**Sent:** 15 June 2018 23:06  
**To:** Richard Sakyi <r.sakyi@welhat.gov.uk>  
**Subject:** application ref no 6/2018/0501/house

Following our telephone conversation we had today regarding the proposal of the raised decking at 12 Coulter Close.

BLOCK PLAN 1-200

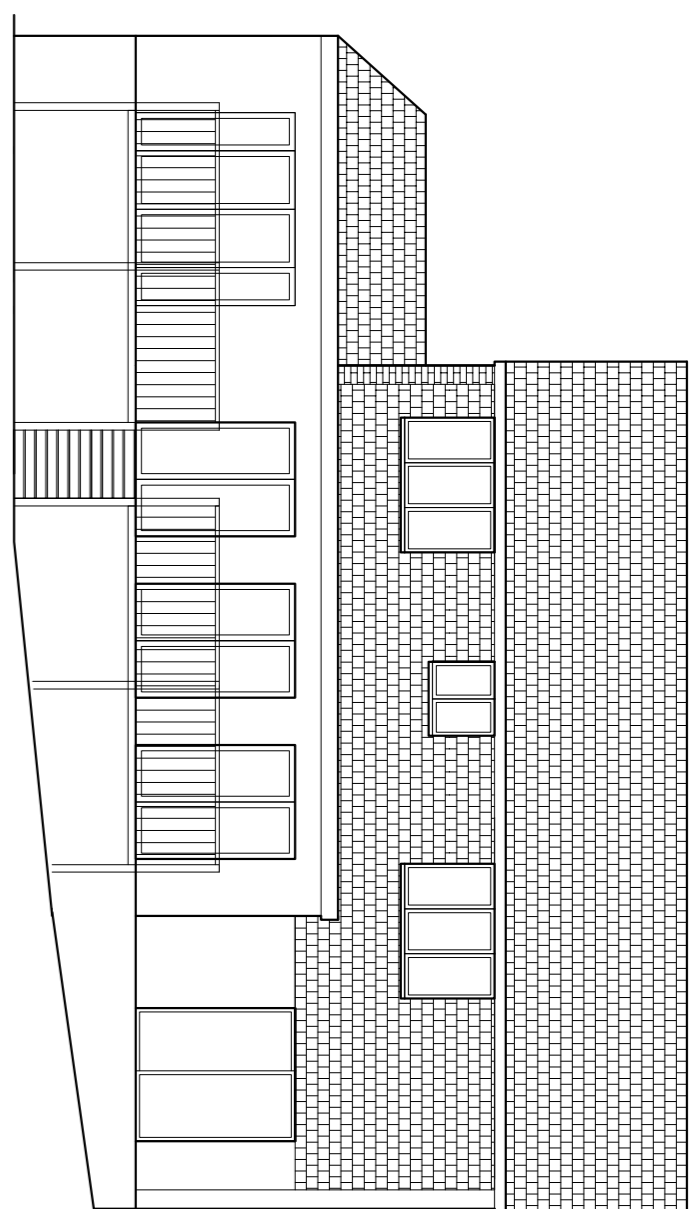
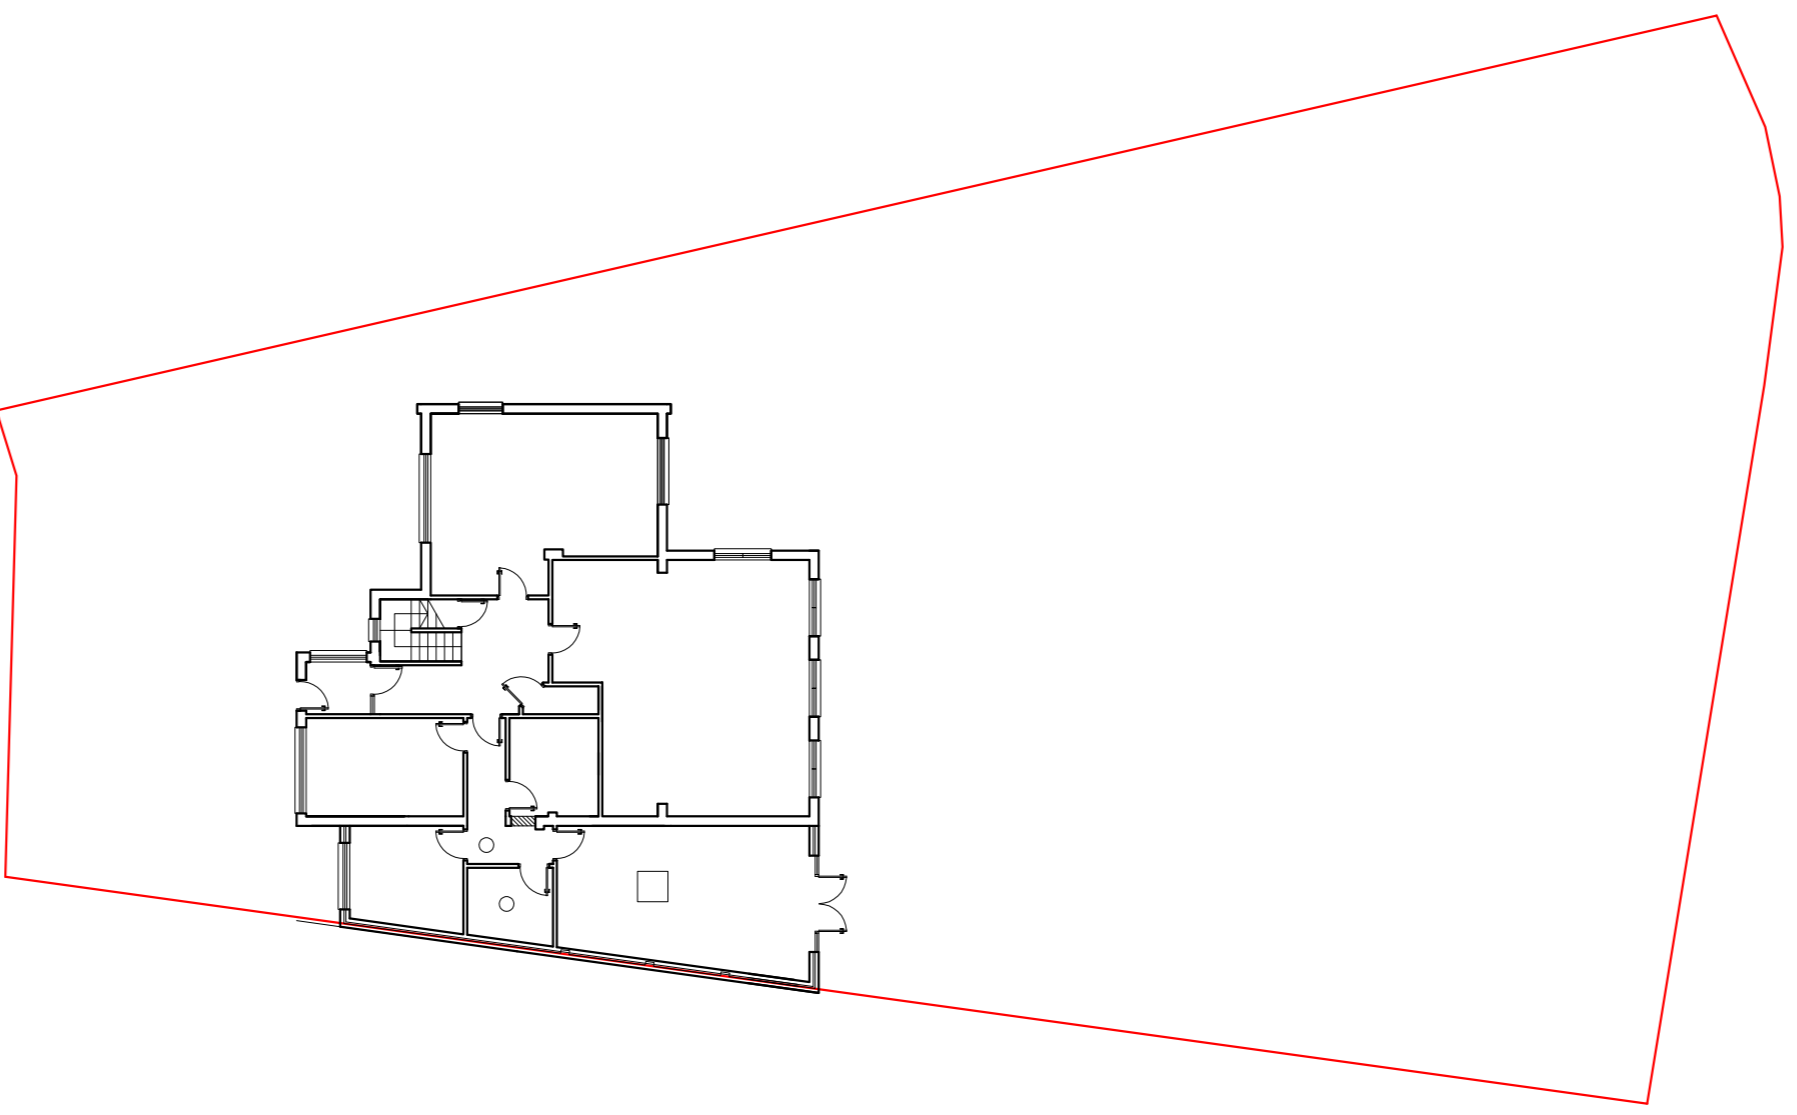
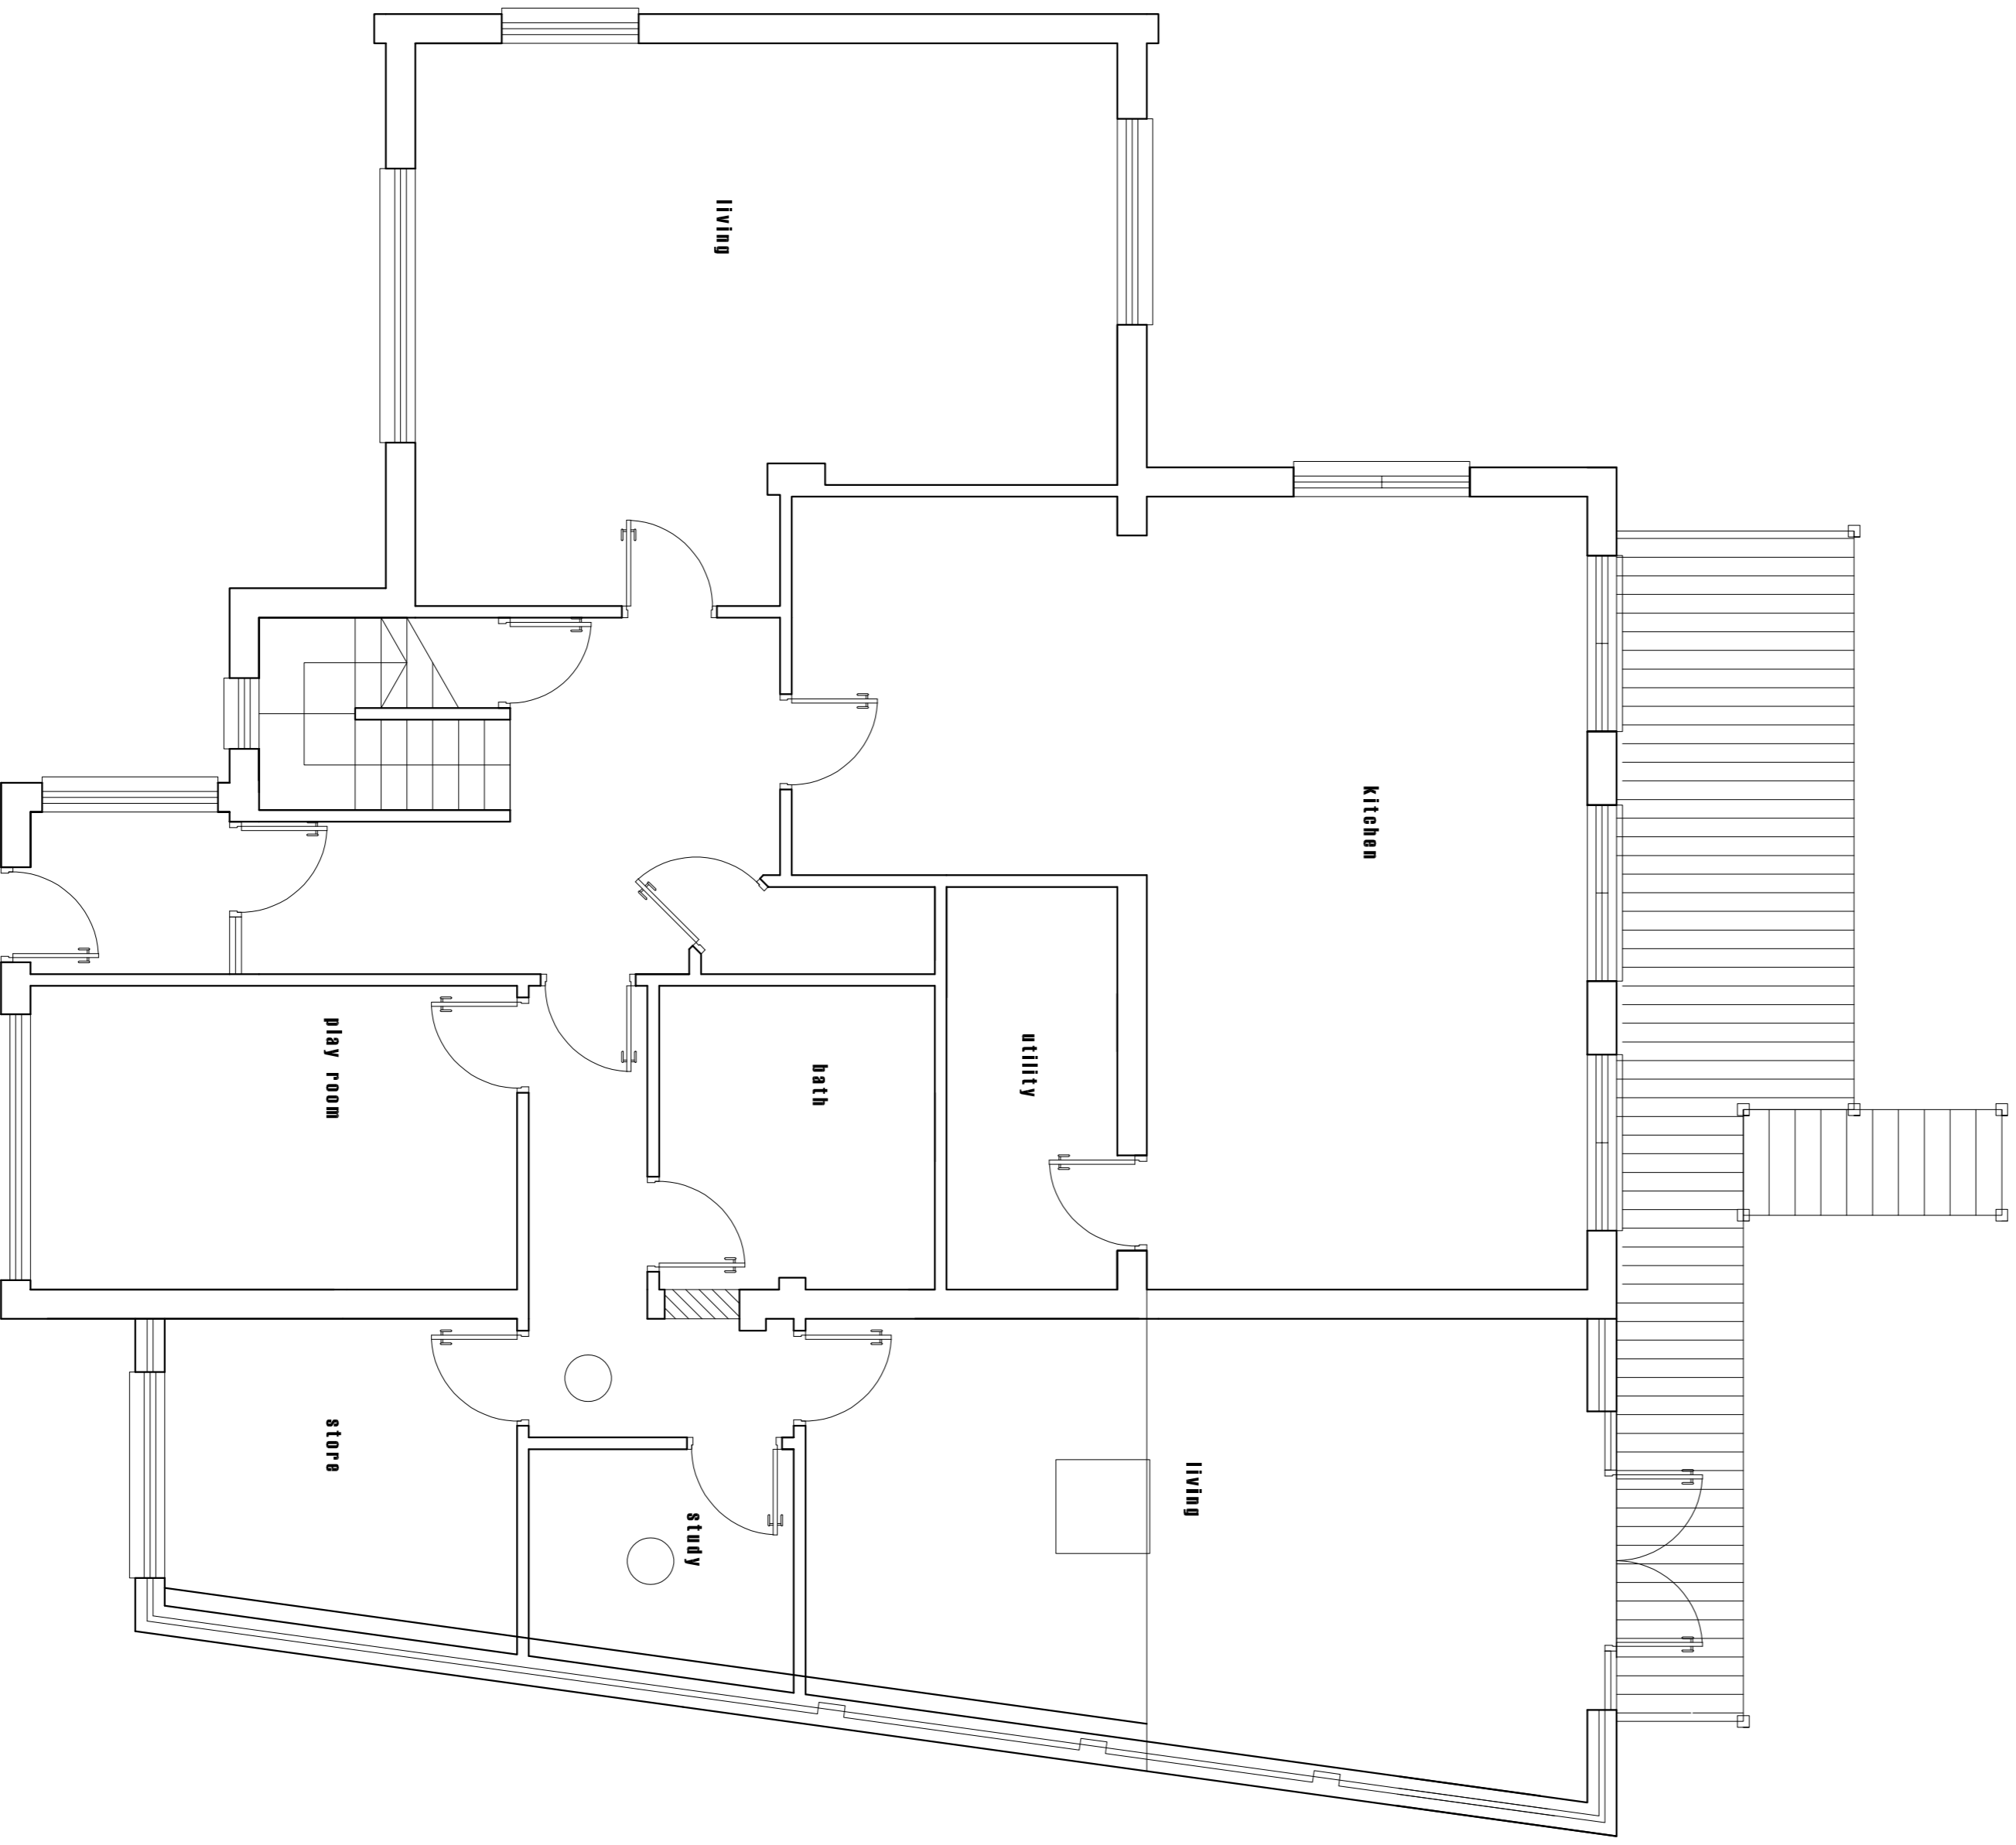
When they submitted plans for a single storey extension in 2014 (ref no S6/2014/2277 show living room /study room /store room no mention of kitchen also on the block plan it does not show the summer house, but in the new plans for the raised decking it shows the summer house on the block plan!

The issue with the raised decking is our invasion of privacy, when they stand on their decking they can look directly into our house.
